Wignal's Gate, Holbeach - Highways and LLFA Response Table
H09-0721-25

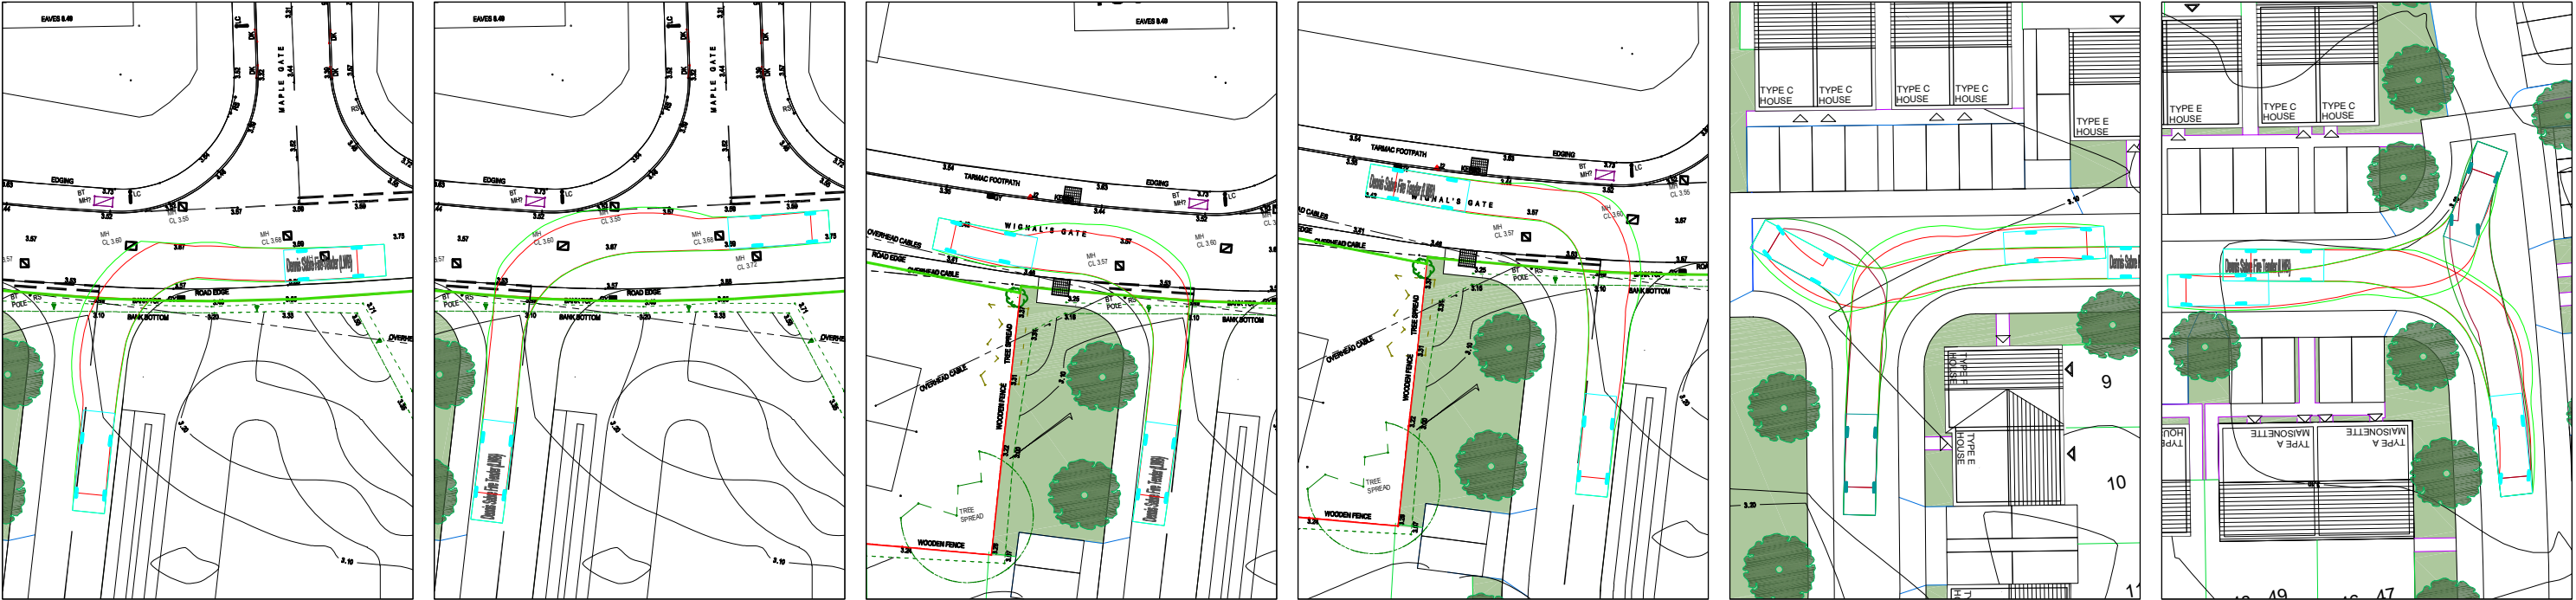
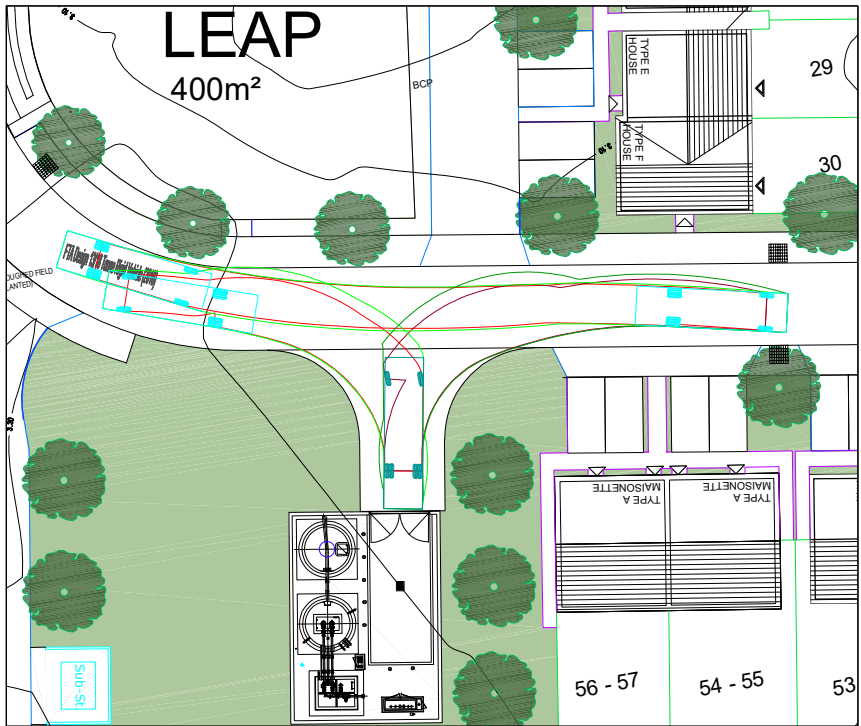
Lincolnshire County Council (LCC) Comment	Our Response	Drawing Reference
An edge lane should be incorporated into the layout instead of the two private drives to provide connectivity and the vehicle tracking does not work for a refuse vehicle as they should not overrun the footways. This looks to happen on several bends/turning areas.	As discussed in our call with LCC on the 1st October 2025, it's not feasible given the site area available to incorporate an edge lane linking what are the private drives. This was accepted at discussion.	
A shared surface road to the east of the site should be considered due to the vehicle access points and continuous flat kerbing.	See revised drawing.	12773-WMS-ZZ-XX-D-C-39501-S8-P3-S38_ADOPTABLE_EXTENTS-25.12.12
Remove any unnecessary areas of footway around turning heads.	See revised drawing.	102-575-001P Planning Layout
A coloured-up Section 38 drawing is required to ascertain what would be put forward for adoption.	See revised drawing.	12773-WMS-ZZ-XX-D-C-39501-S8-P3-S38_ADOPTABLE_EXTENTS-25.12.12
